**KIRKLEES METROPOLITAN COUNCIL
INVESTMENT & REGENERATION SERVICE**

**DELEGATED DECISION TO DETERMINE PLANNING APPLICATIONS TO
CARRY OUT DEVELOPMENT WITHOUT COMPLIANCE WITH PLANNING
CONDITIONS PREVIOUSLY ATTACHED**

Reference No: 2017/70/92557/W

Description: Variation condition 1 (plans) on previous permission
2016/93365 for reserved matters application pursuant
to outline permission 2014/91533 for erection of 30
dwellings

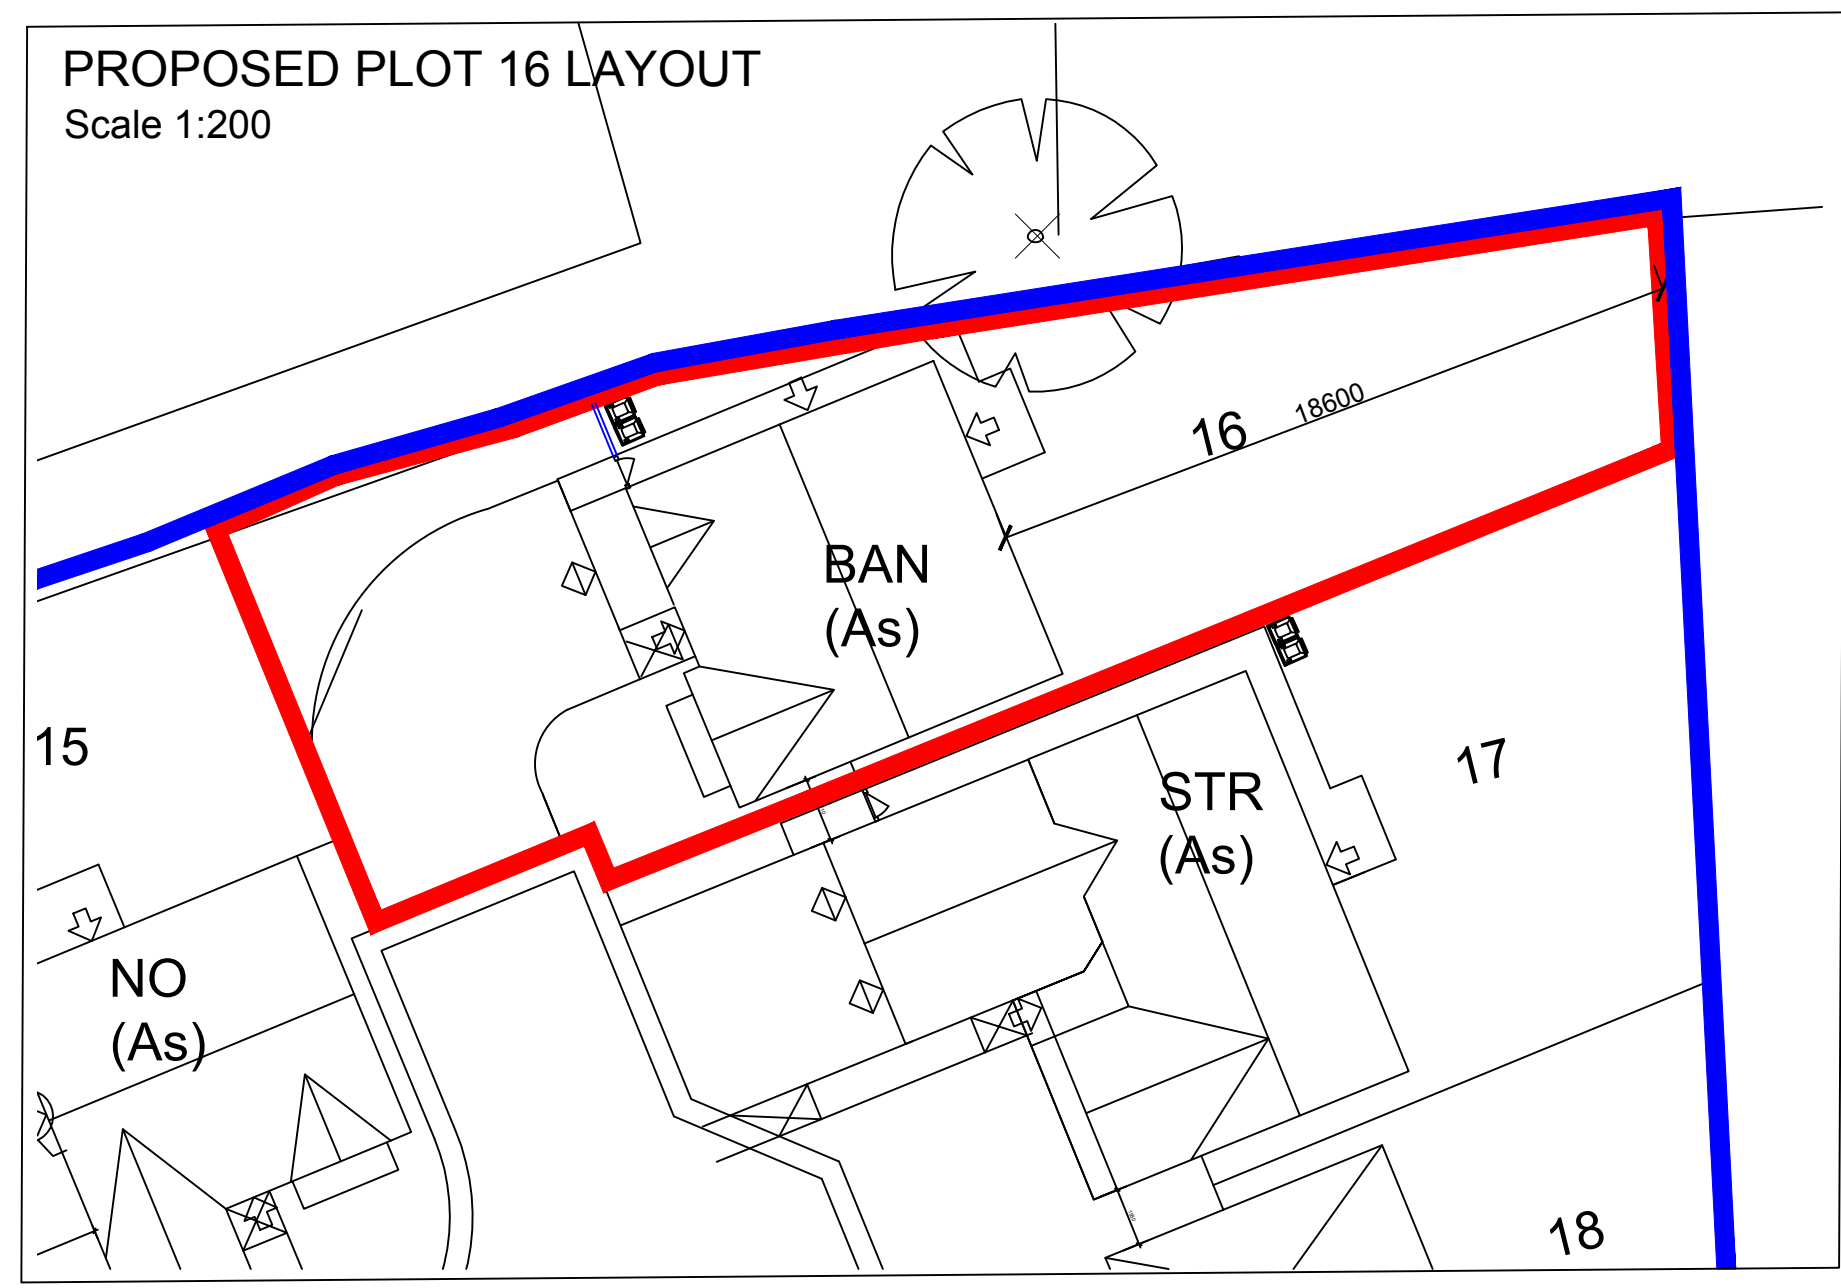
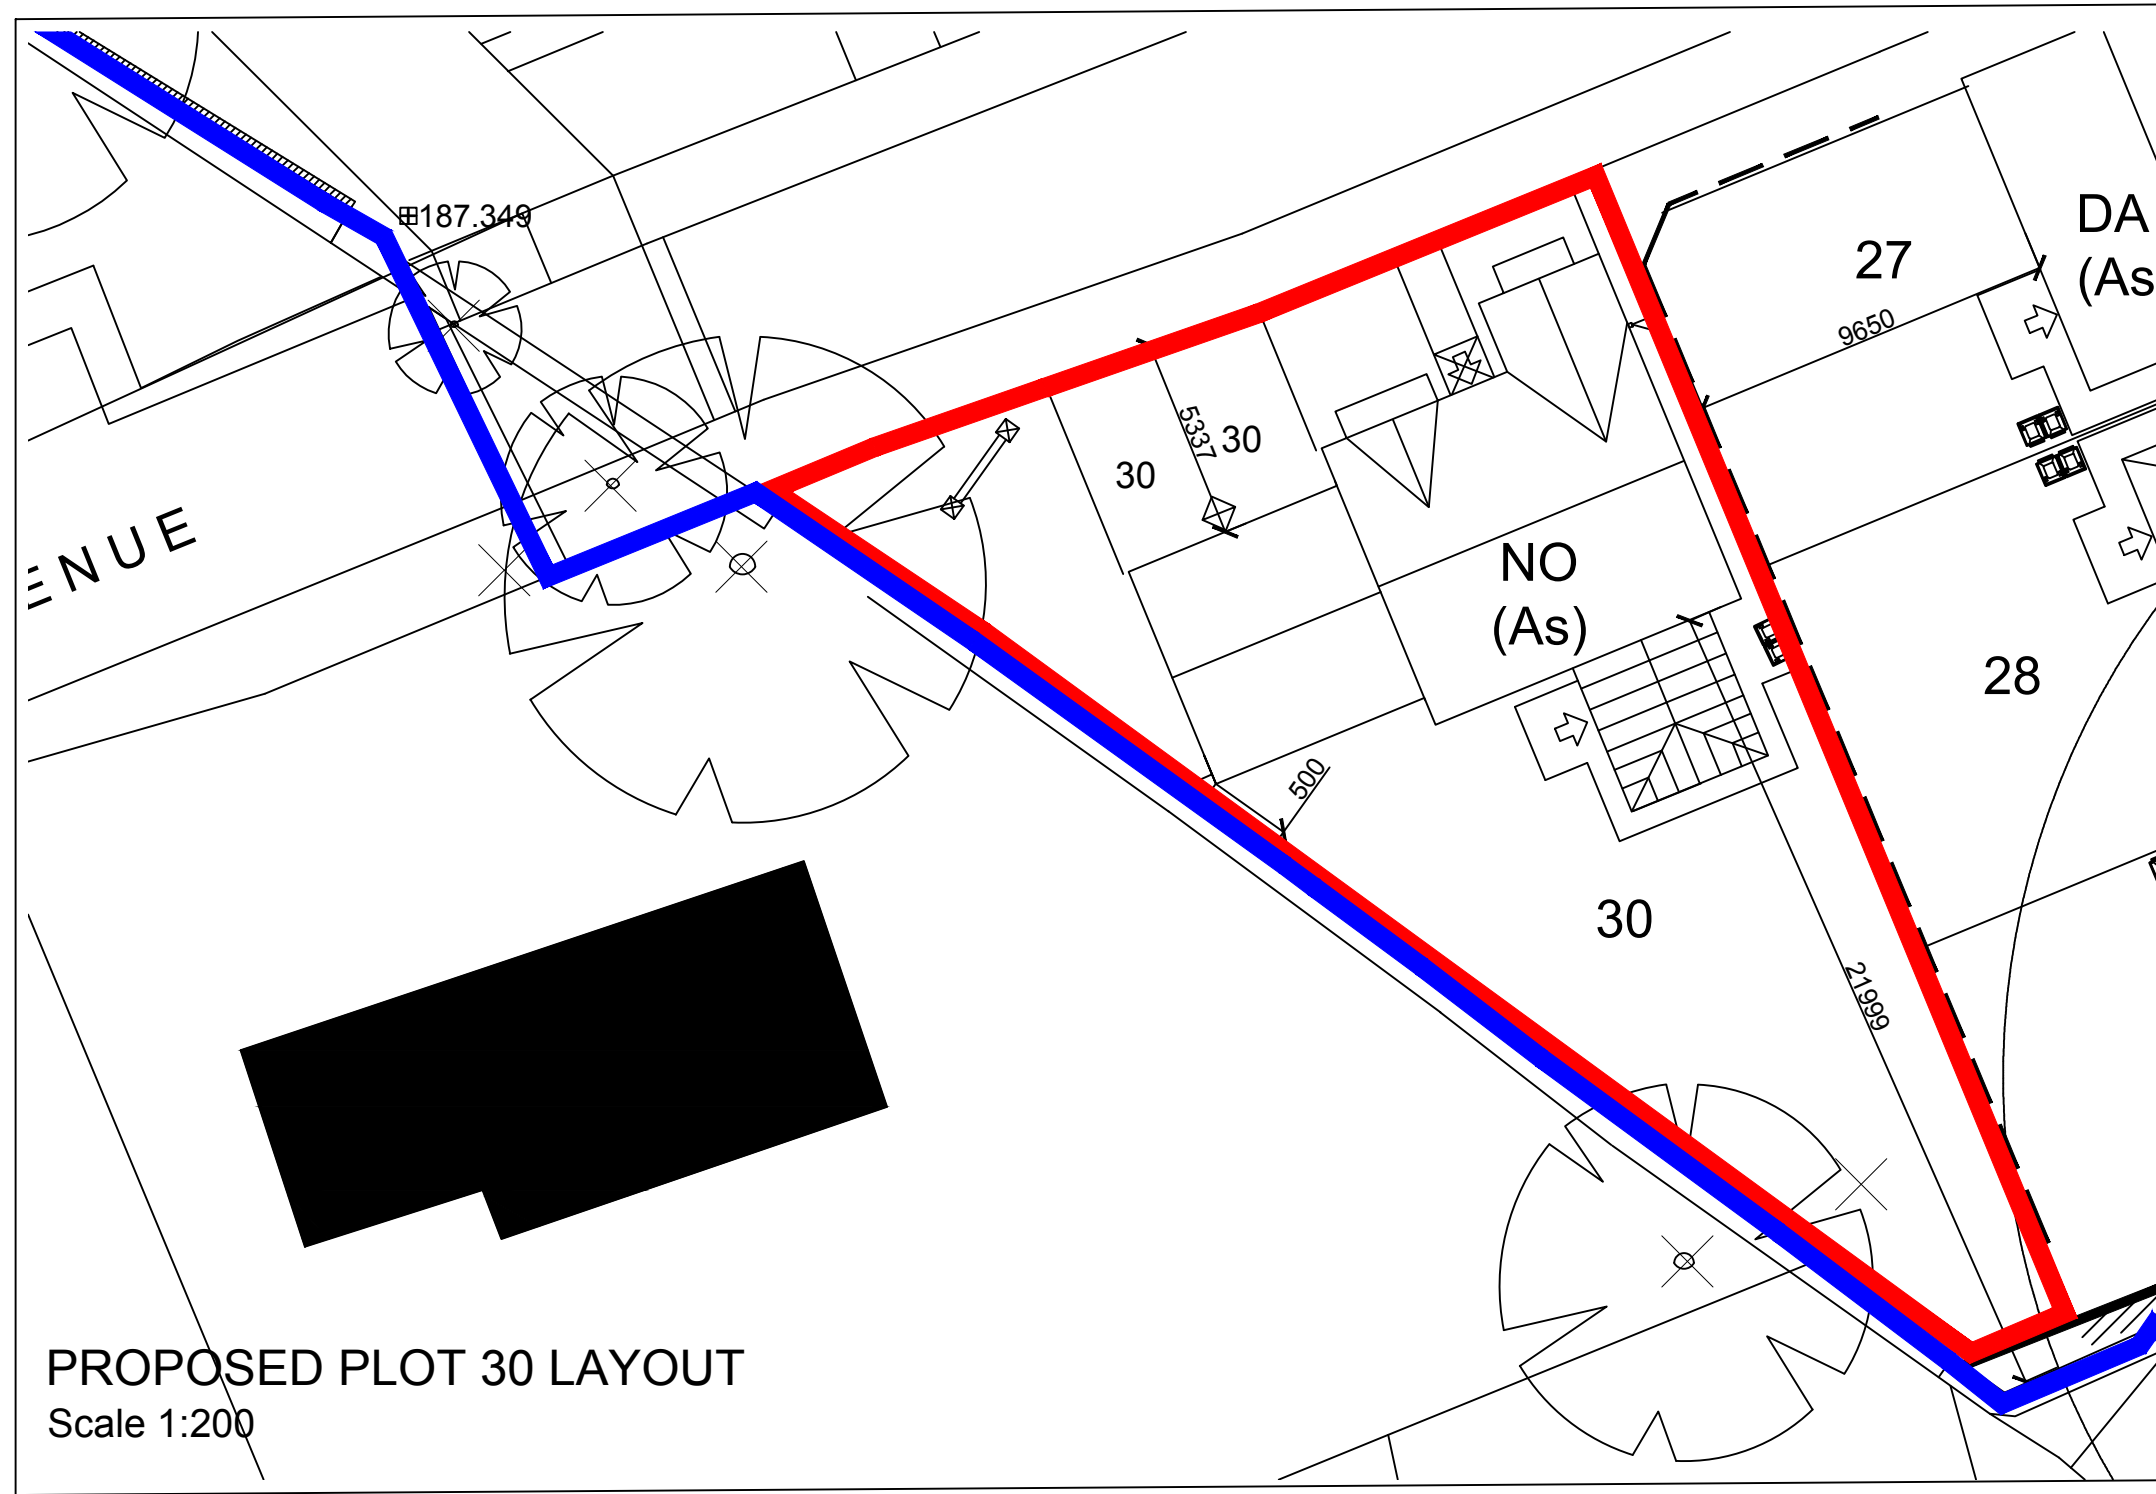
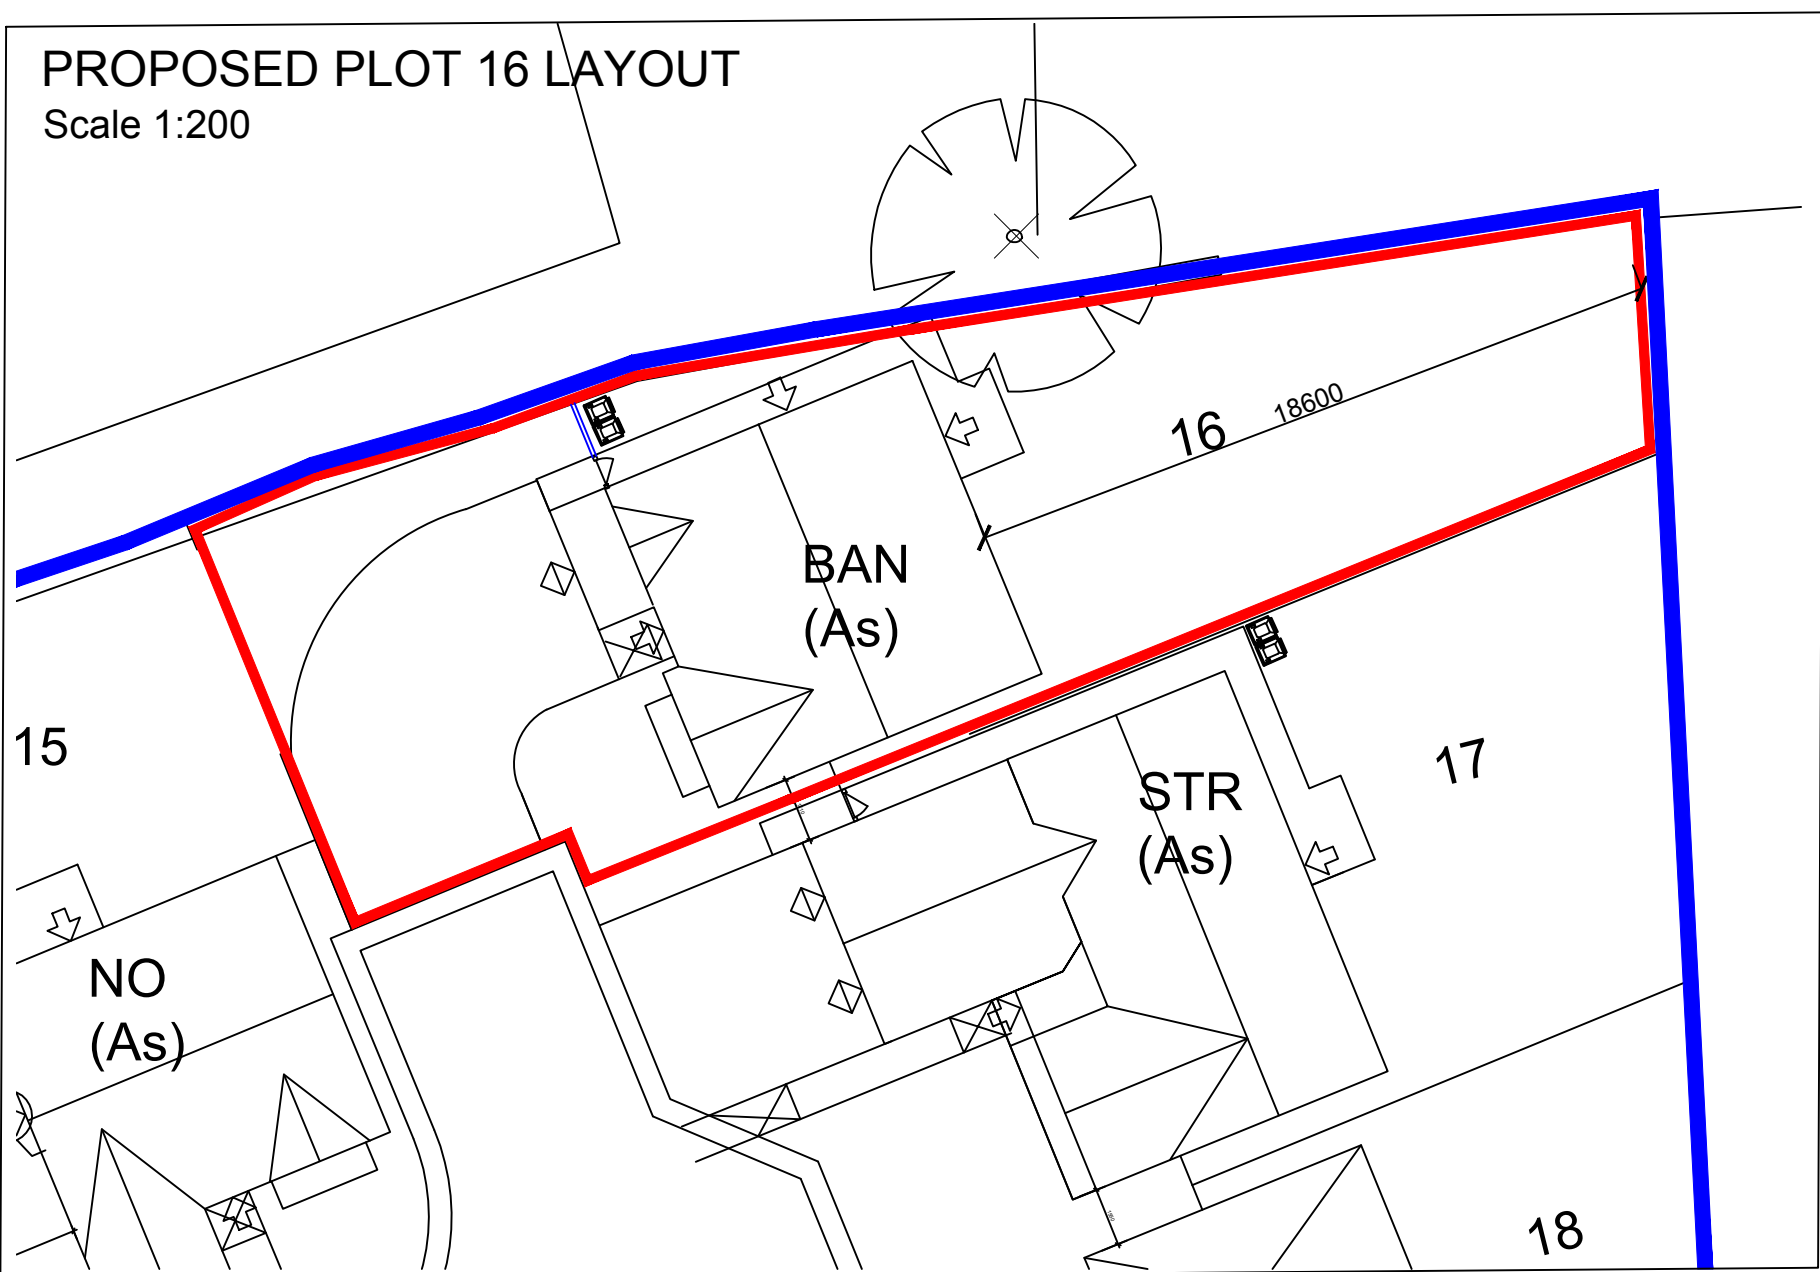
Plot 16: It is proposed to amend the house type from 'Styal' (4 bed) to 'Banbury' (4 bed). The reason for the proposed change is to accommodate the proposed surface water drainage strategy. The change repositions the dwellinghouse and reduces its footprint allowing for necessary stand-off distances to drainage infrastructure.

Officers have negotiated with the applicant an amendment to the proposed double garage on plot 30 to mitigate the impact on an adjacent existing property (6 St Mary's Ave).

- The double garage has been reduced in width by 0.55m to achieve 12m separation to the side elevation of 6 St Mary's Ave
- The garage roof has been hipped to reduce its massing

In addition, the developer has decided to re-orientate the conservatory doors towards the length of the garden rather than towards 6 St Mary's Ave to mitigate any potential privacy concerns.

The amendment to the proposed double garage has made it acceptable. The garage has been moved slightly further away from 6 St Mary's Avenue which enables it to comply with Policy BE12. The pitched roof of the garage has also been changed to a hipped roof which reduces the bulk and mass of the garage as perceived from the neighbouring property. It is to be noted as well that plot 30 is set down slightly from 6 St Mary's Avenue which also helps to mitigate the impact of the garage in these circumstances. Overall I am satisfied that the amenity of 6 St Mary's Avenue would not be significantly harmed by the change.

To accommodate the double garage the property has been moved 0.8m to the east. The position of plots 24, 27, 28 and 29 have also been revised to accommodate the larger plot for plot 30. The separation between plot 30 and plot 27 to the east remains acceptable, especially as this is a new dwelling to new dwelling relationship and no existing occupiers would be prejudiced in any way. The repositioning of plots 24, 27, 28 and 29 is very minor and do not result in any material impacts.
